Online Comment

Application H16-1045-21
Location 17 Winsover Road Spalding PE11 1EG
Proposal Installation of wall mounted air conditioner units - retrospective

TITLE
Air Conditioner
Outdoor Units

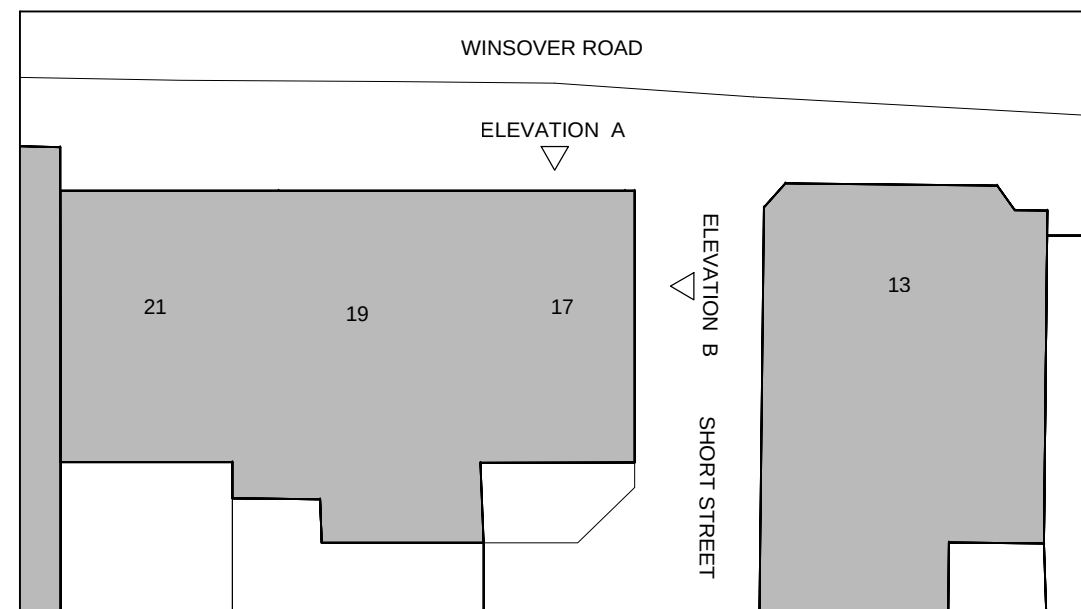
Hi, I can now clarify with you that our vehicles would be ok collecting from the collection point under these air condition units as long as they are placed above 4 meters high. Our vehicles should fit with ease.
